**EROSION CONTROL AND
STORMWATER MANAGEMENT PLAN
FOR
STERLING RANCH EAST FILING NO. 2
PCD FILE NO. SF-22-XXX**

SF2237

EROSION & STORMWATER QUALITY CONTROL PLAN FOR STERLING RANCH EAST FILING NO. 2

STERLING RANCH EAST FILING NO. 2
CONSTRUCTION PLANS
INTERIM GRADING AND EROSION CONTROL PLAN

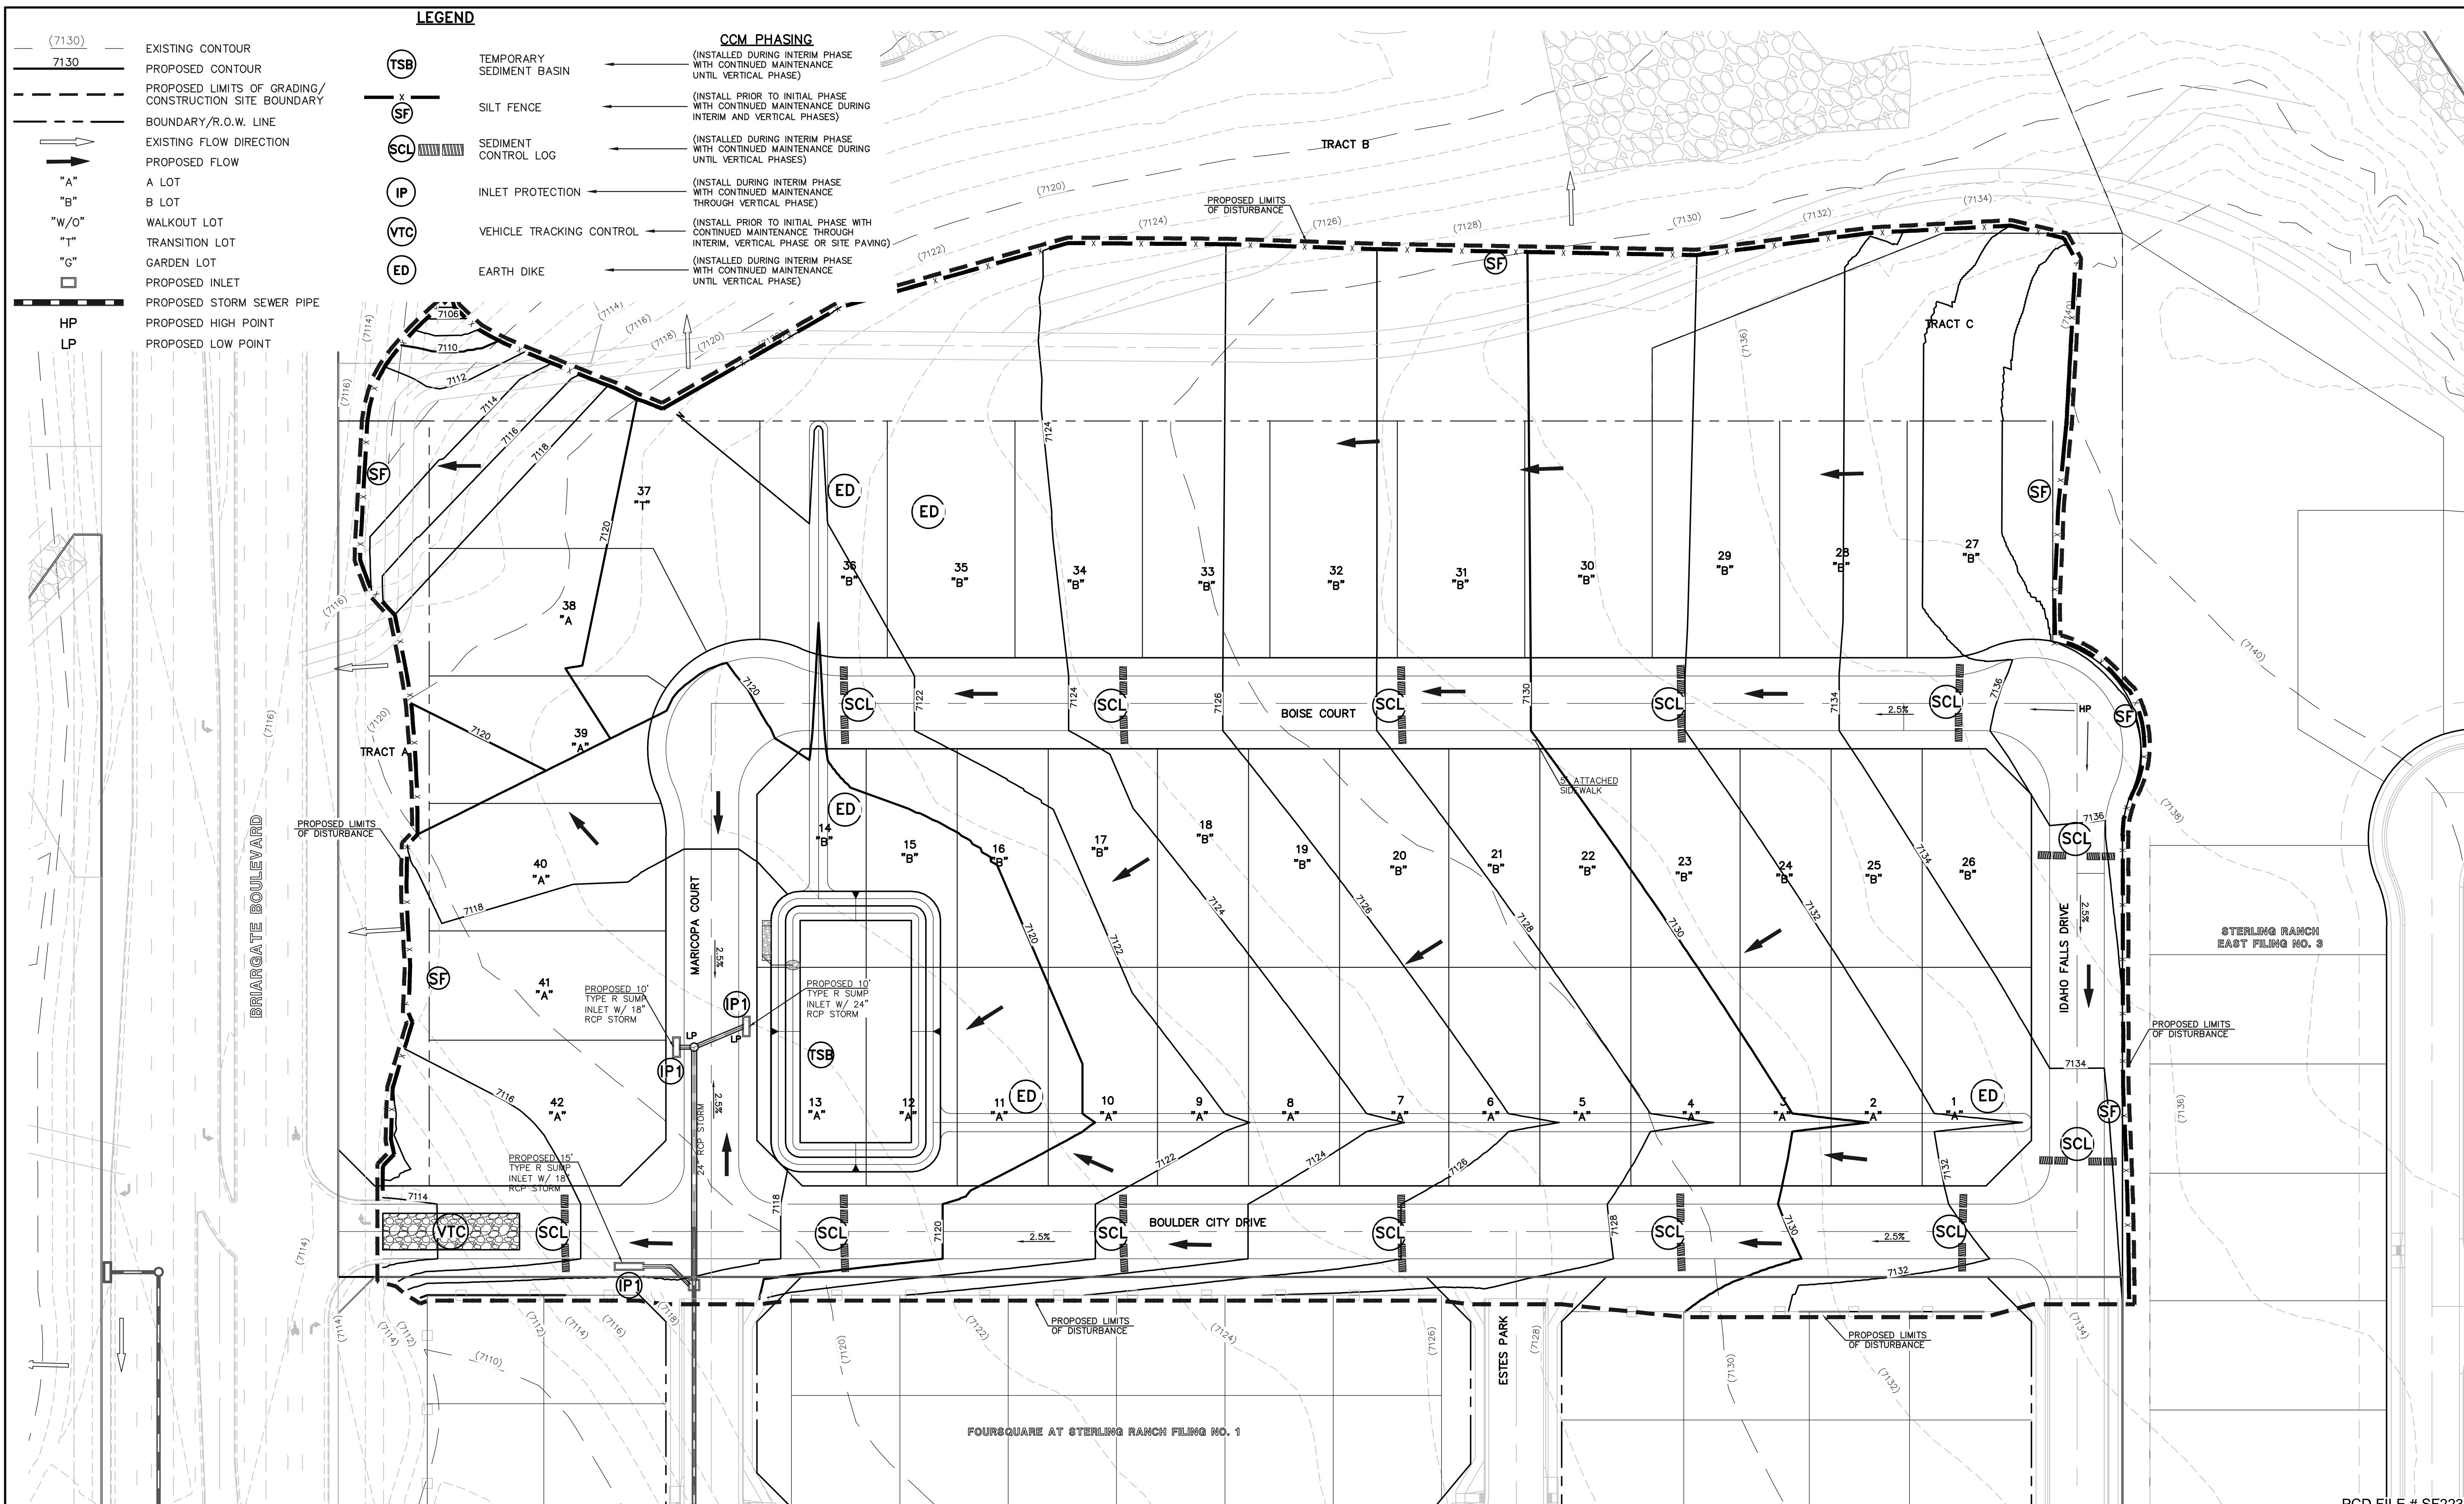
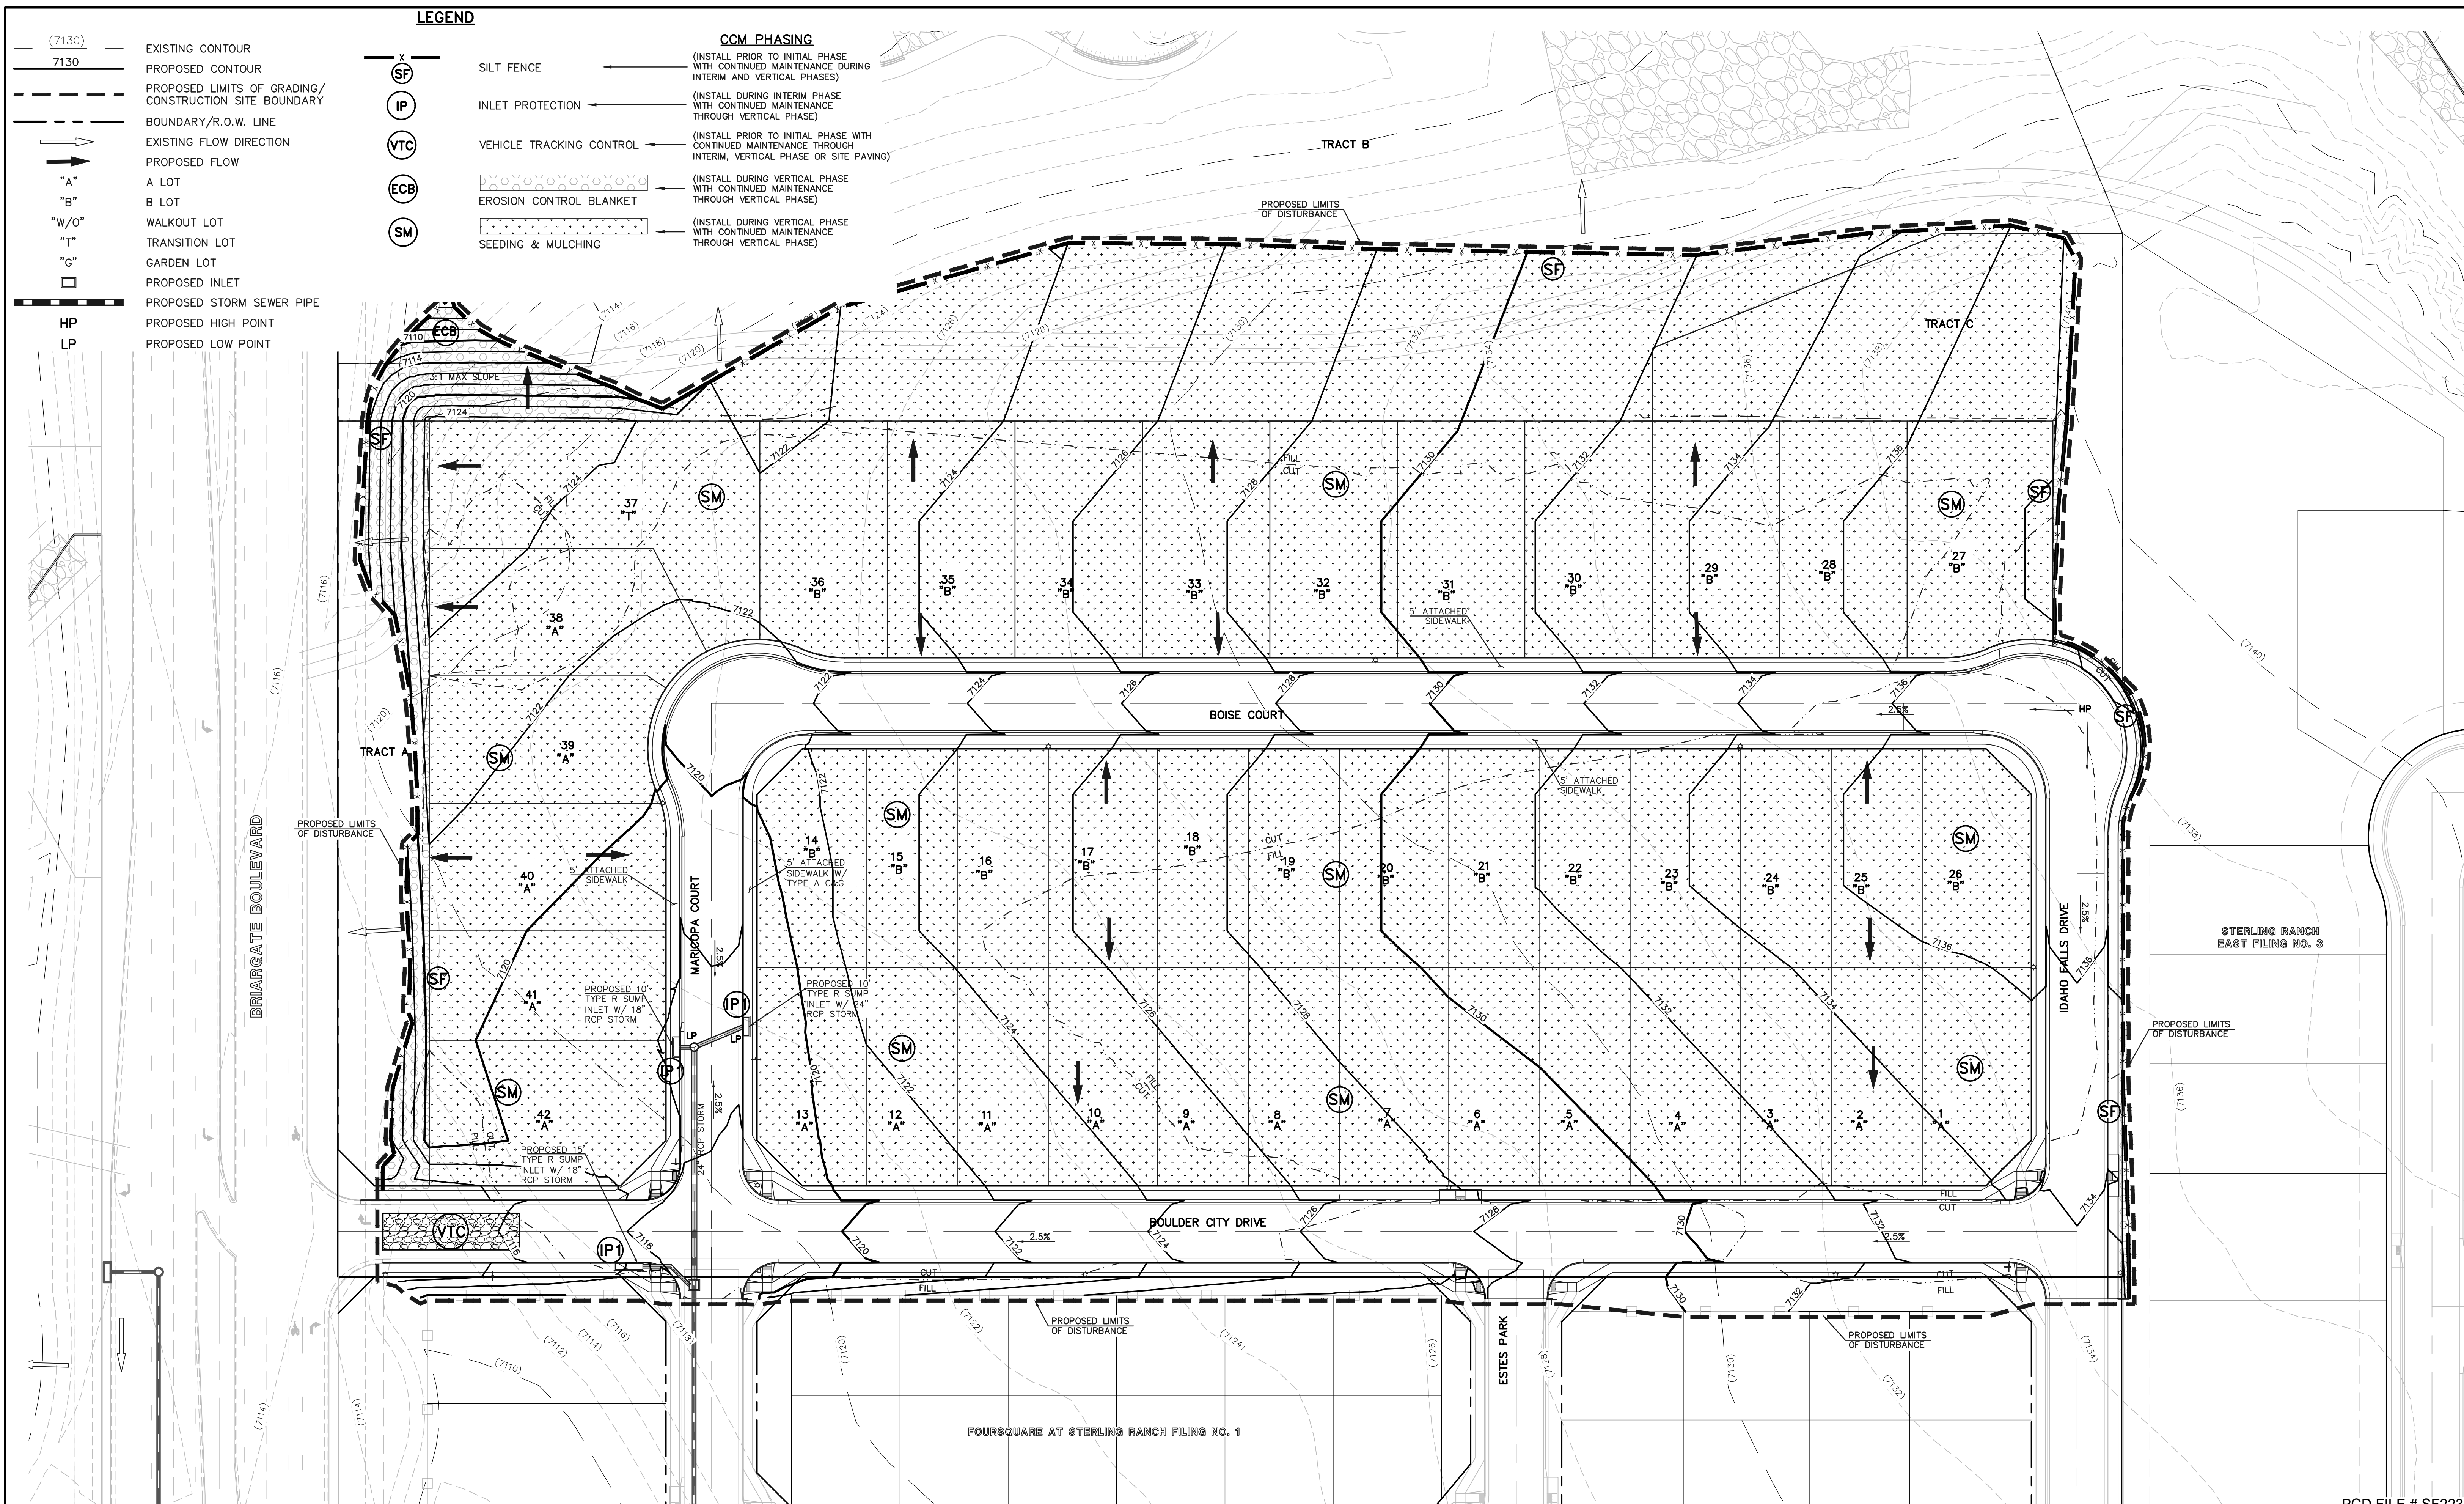
Show locations of these swales and basins on GEC Plans.
